My Ref: 2022/0155 (2021/0624)  
Your Ref: As above  
Date: 2 August 2022  
Enquiries to: Helen Willows  
Direct Dial: 01226 772642  
E-Mail: [helenwillows@barnsley.gov.uk](mailto:helenwillows@barnsley.gov.uk)

**Re: Discharge of conditions 3 (External materials), 4 (Hard surfacing materials), 5 (air conditioning) and 6 (cooking equipment and fume extract system) of planning permission 2021/0624 – Hot food delivery and takeaway hub (amendment to previously approved application 2020/1249) at Former Frankie and Benny's, Doncaster Road, Stairfoot, Barnsley, S70 3PE.**

drawing title	Preliminary Layout
---------------	---------------------------

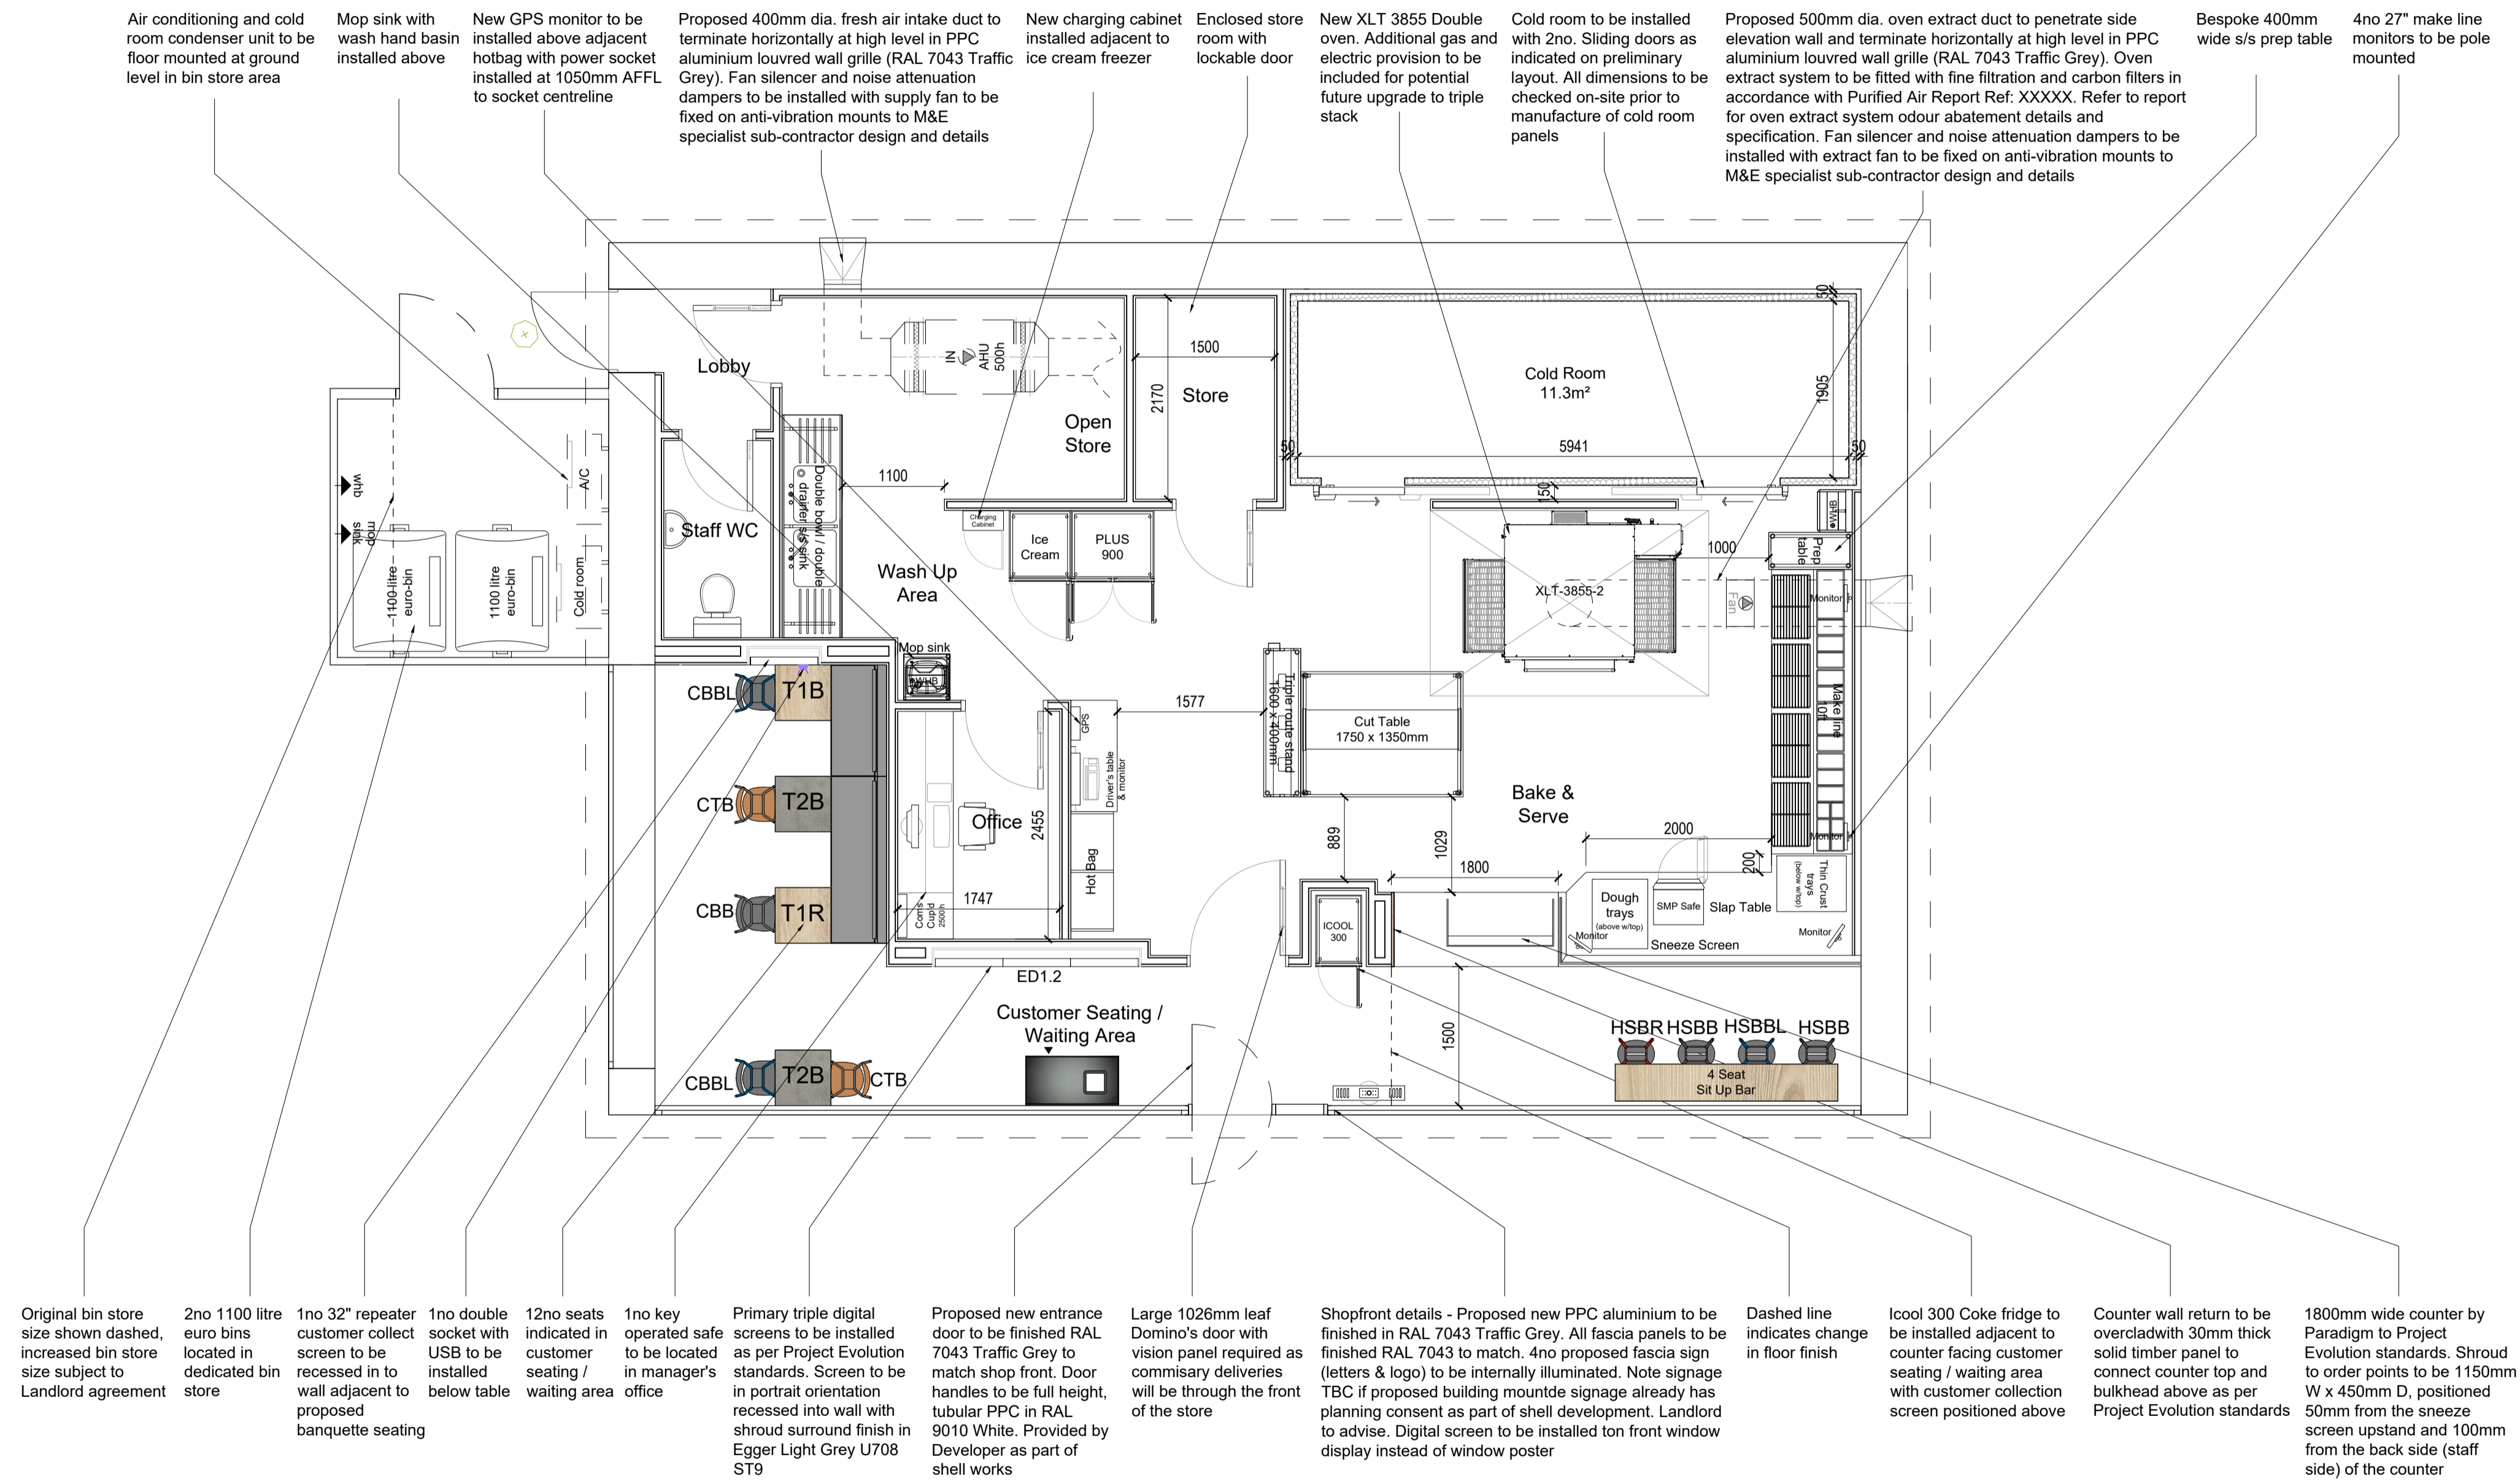
3. Air conditioning and cooking equipment and fume extract system details shown on layout plan drawing submitted with your application.

Notwithstanding the above I would raise the point that the plans submitted with the above discharge of condition application show a different internal layout to the versions approved under planning applications 2021/0624 and 2020/1249 in relation to showing an increased amount of internal seating provision. The applicant is reminded that the aforementioned applications were submitted as hot food takeaway hubs which would be one type of sui generis use and were not assessed on the basis of it being a facility intending to allow for dining in on the premises which would be a mixed sui generis and class E use. Should that be the intended or eventual use the applicant is advised that would not be covered by the existing planning permissions meaning that a new application would be required to seek approval for a different usage to that which has been approved.

Client: 3D Coffee  
Domino's Barnsley  
Drawing no: 94.20/04.1  
Date: 14/02/2022 Time: 15:32  
Revision: 0 Scale: 1:100, 1:2.39@A1  
Site address: Doncaster Road Barnsley S70 3PE United Kingdom

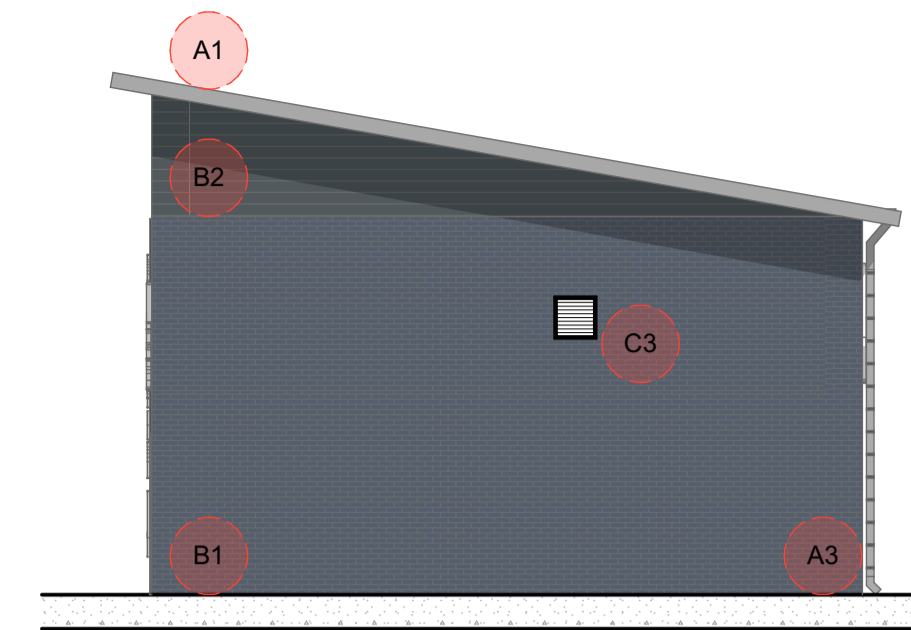
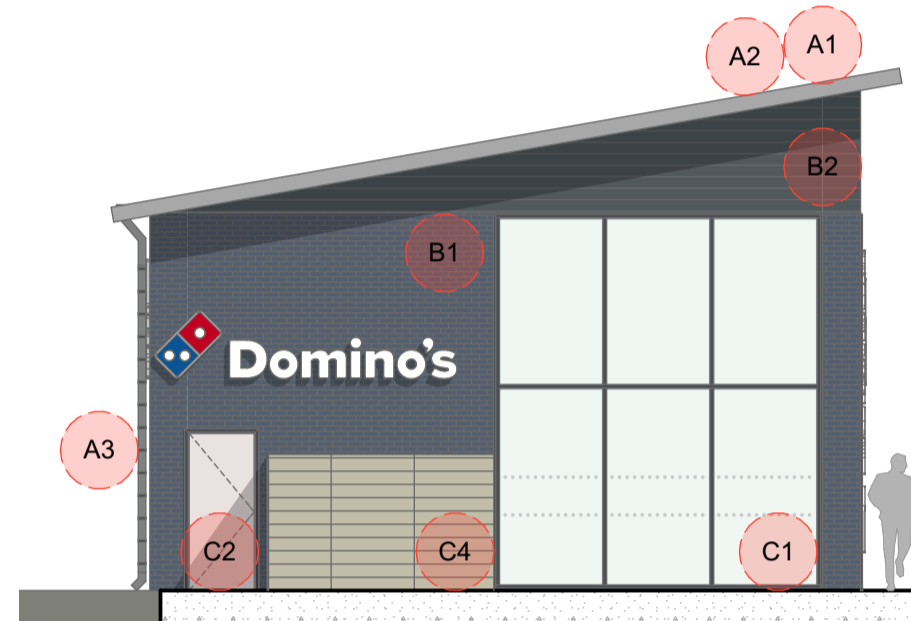
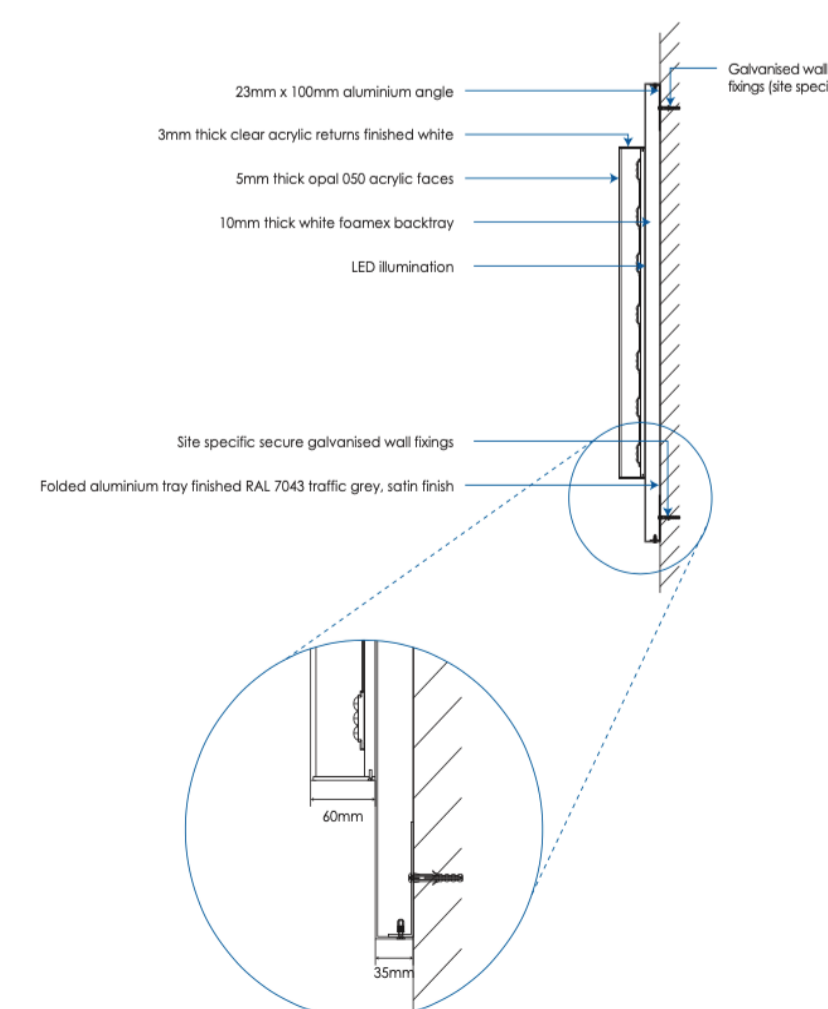
1. Use of plain wire cut Ibstock Cheddar Golden facing bricks as specified in your email of 27 May 2022, (and not the Blue Brick slips or the grey cladding specified on the Plans and Elevations drawing number 92.20.04.1 submitted with your application); Goosewing Grey metal roof cladding and Traffic Grey eaves and soffits, rainwater pipes and entrance door and windows as specified on the Plans and Elevations drawing number 92.20.04.1 submitted with your application.

2. Use of tarmac for the areas to be hard surfaced for parking bays, as specified on the Plans and Elevations drawing number 92.20.04.1 submitted with your application.
